**DEVELOPMENT REVIEW BOARD
ACTION SHEET**

DRB Application No.: 05DRB-01588 (SBP)
Project Name: SEVEN BAR RANCH
Agent: Claudio Vigil Architects

City Of Albuquerque
PLANNING DEPARTMENT
October 19, 2005
DRB Comments

RE: Seven Bar Ranch/SBP

SHEET TITLE
LANDSCAPE PLAN

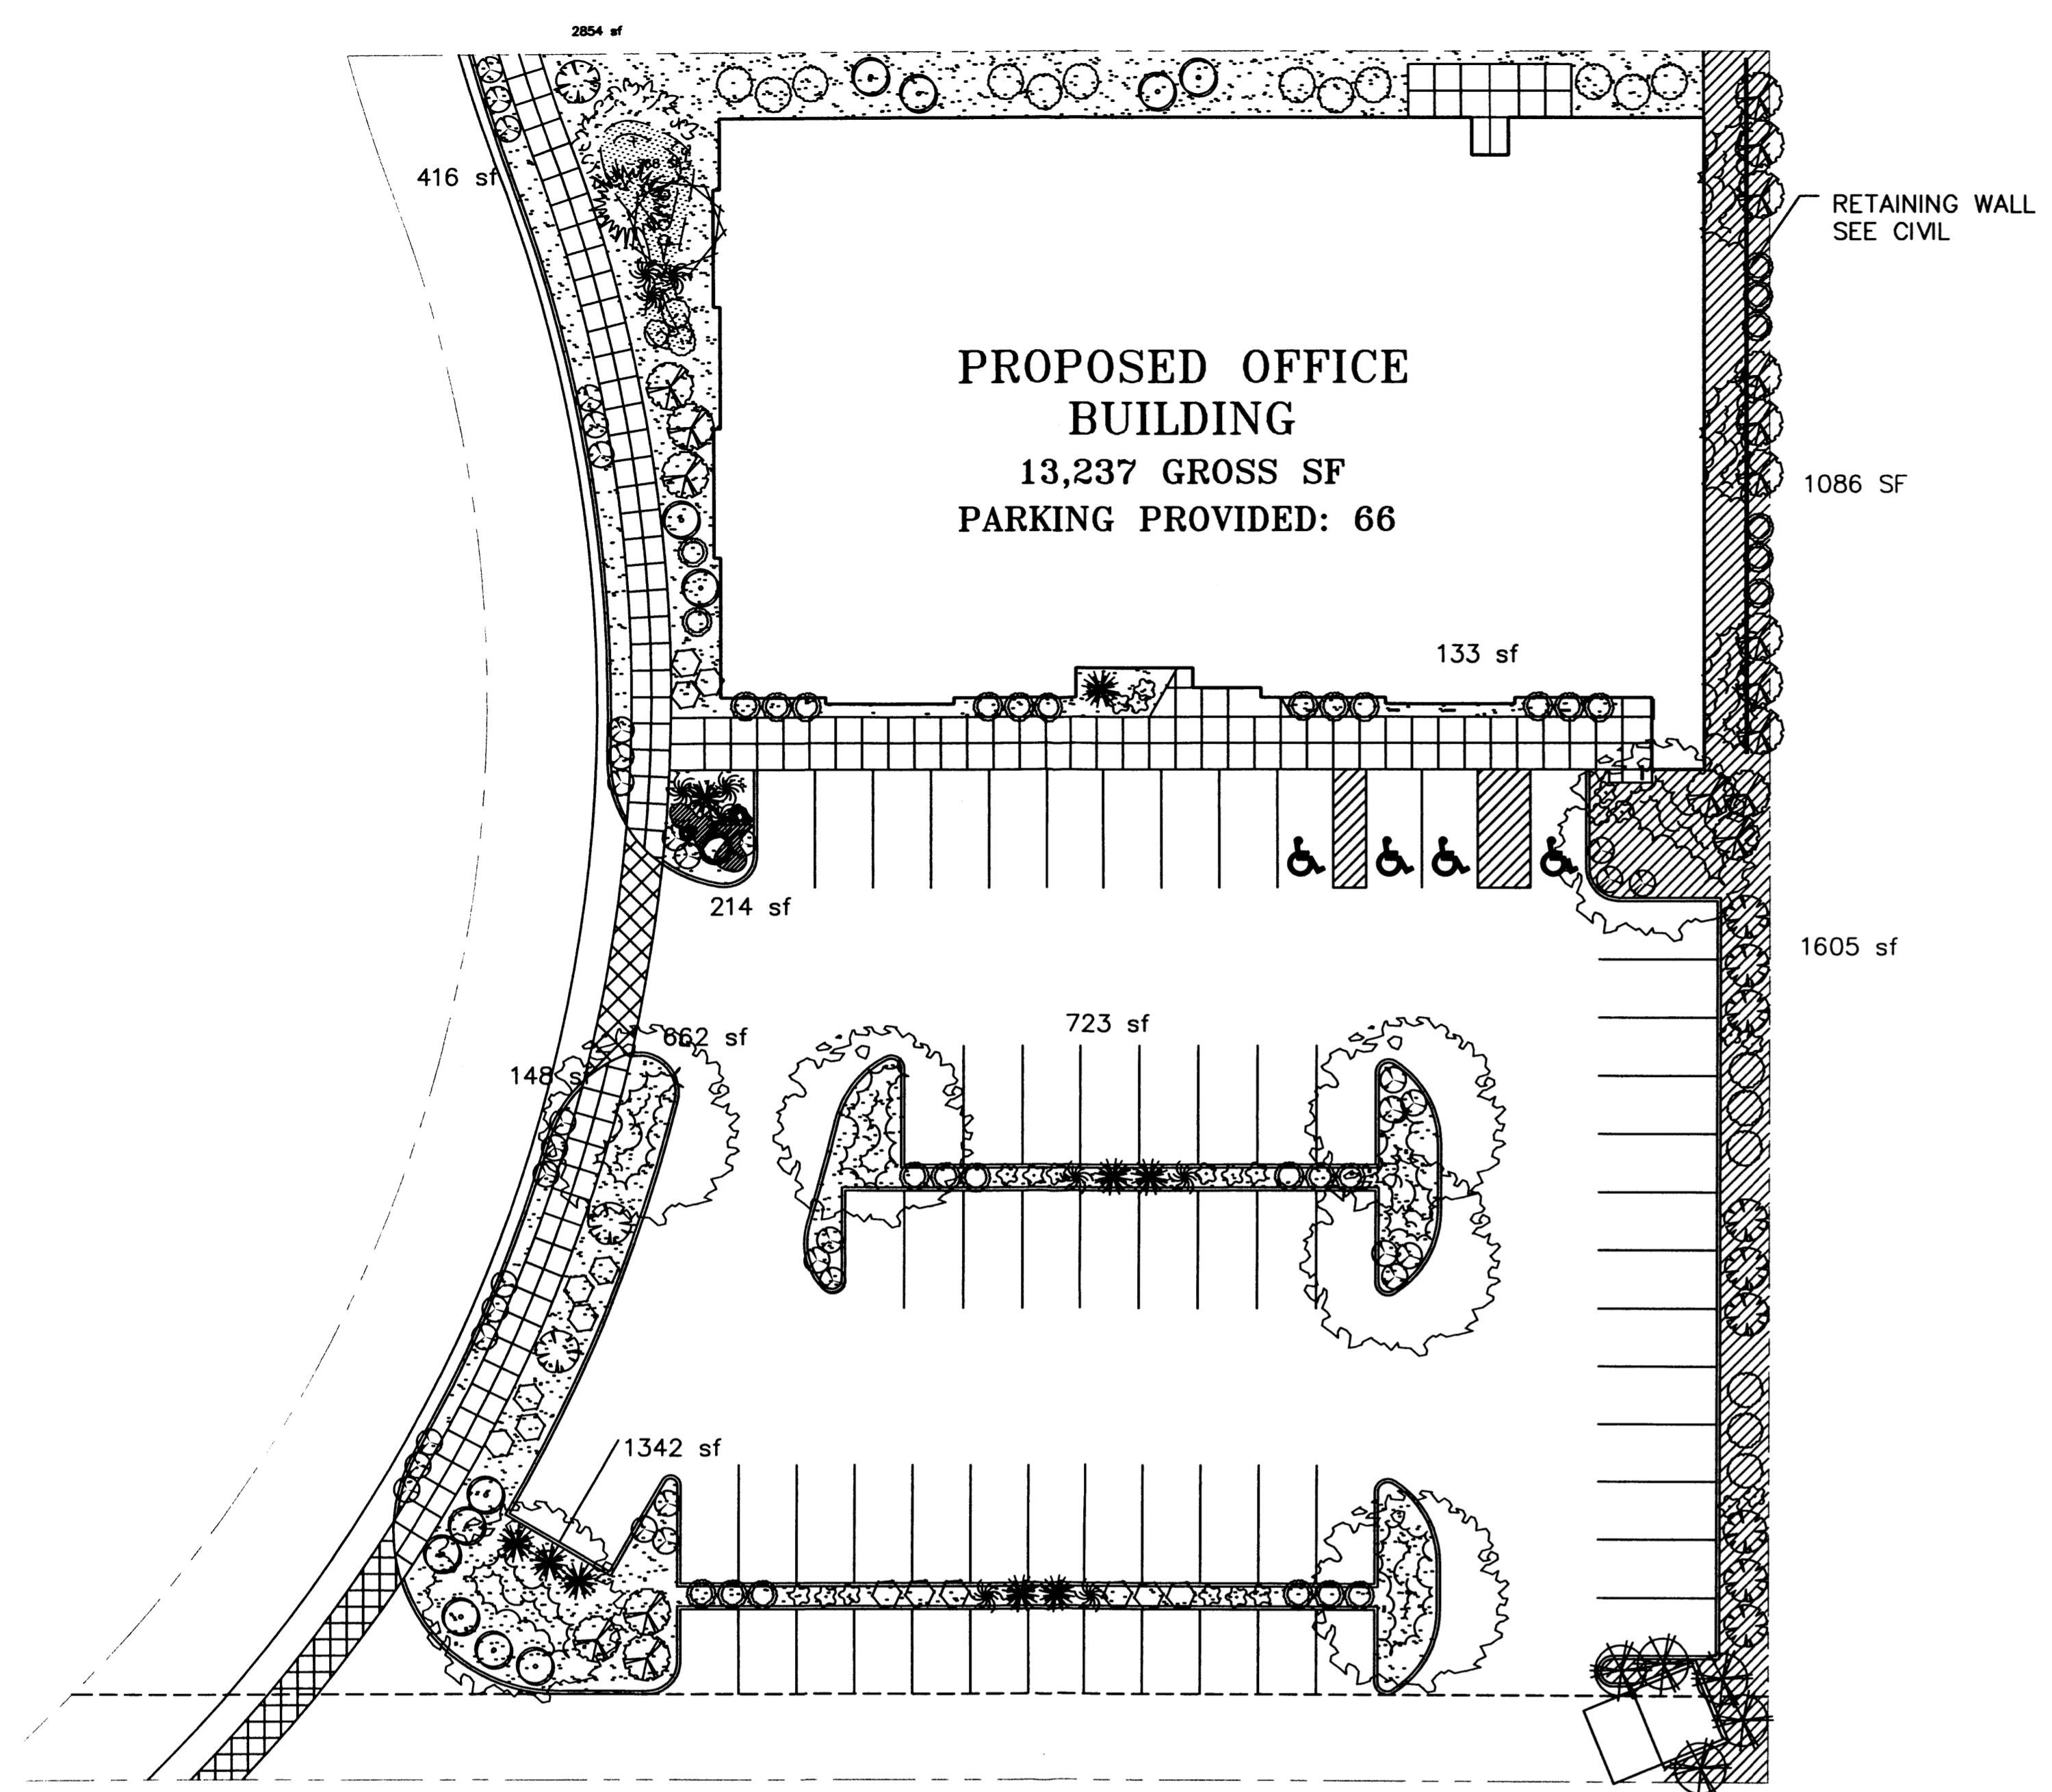
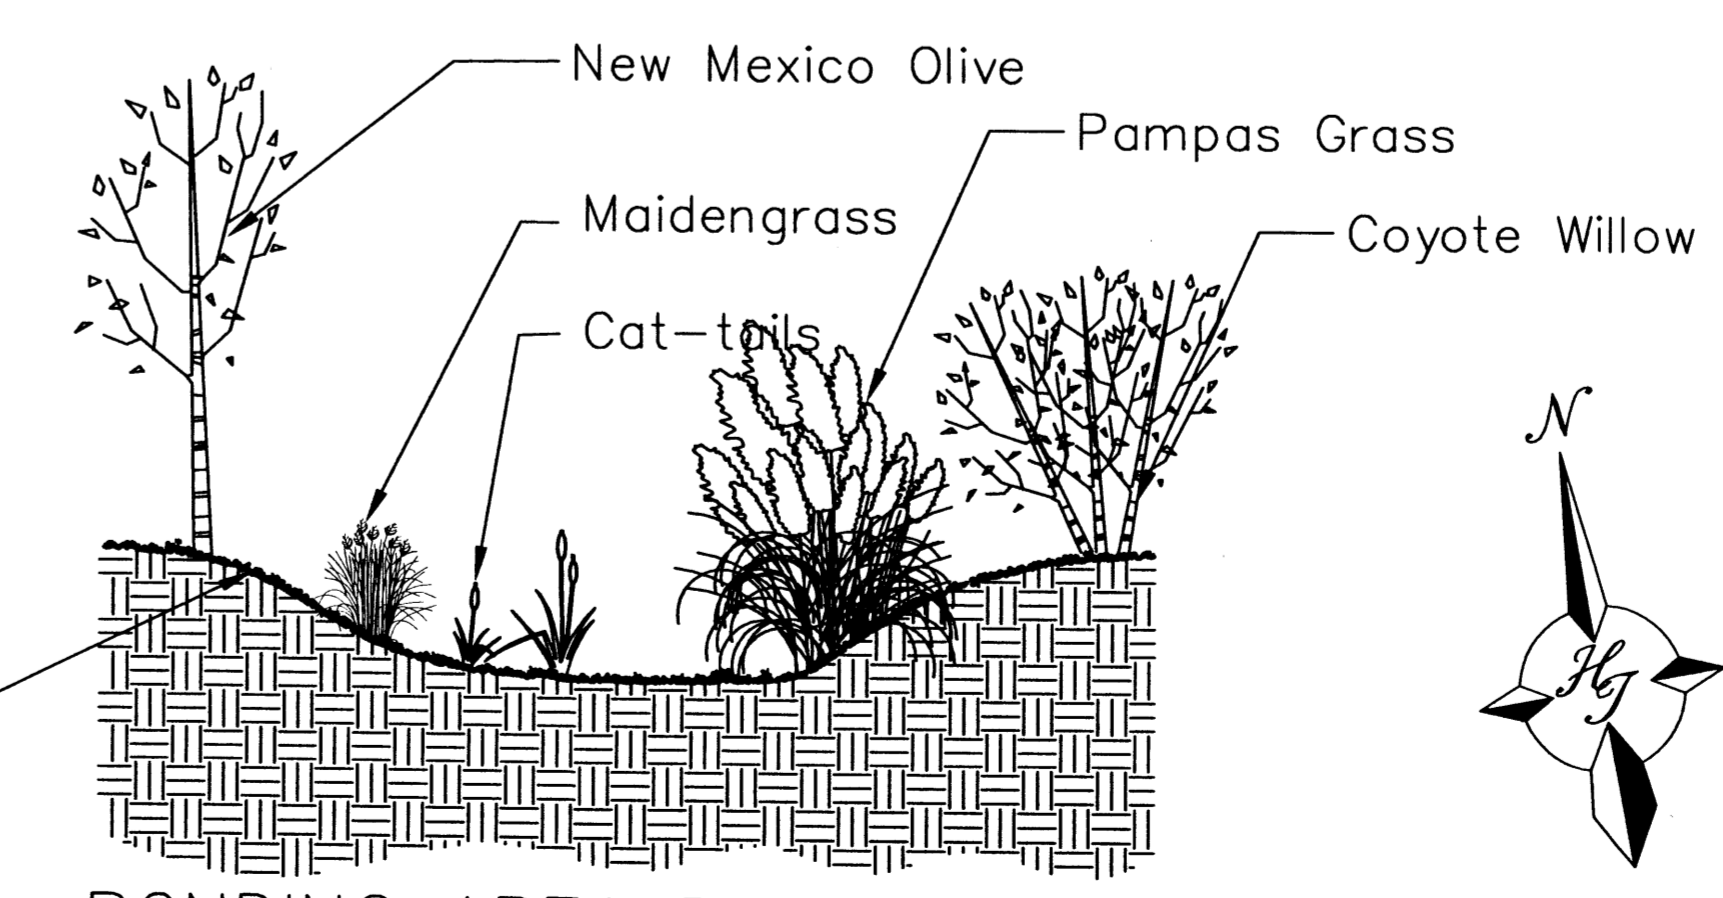
- PLANNING (Last to sign): Replace Tam Juniper with alternate ground cover
-
-
-

Replace Tam Juniper with a different Ground cover/shrub.
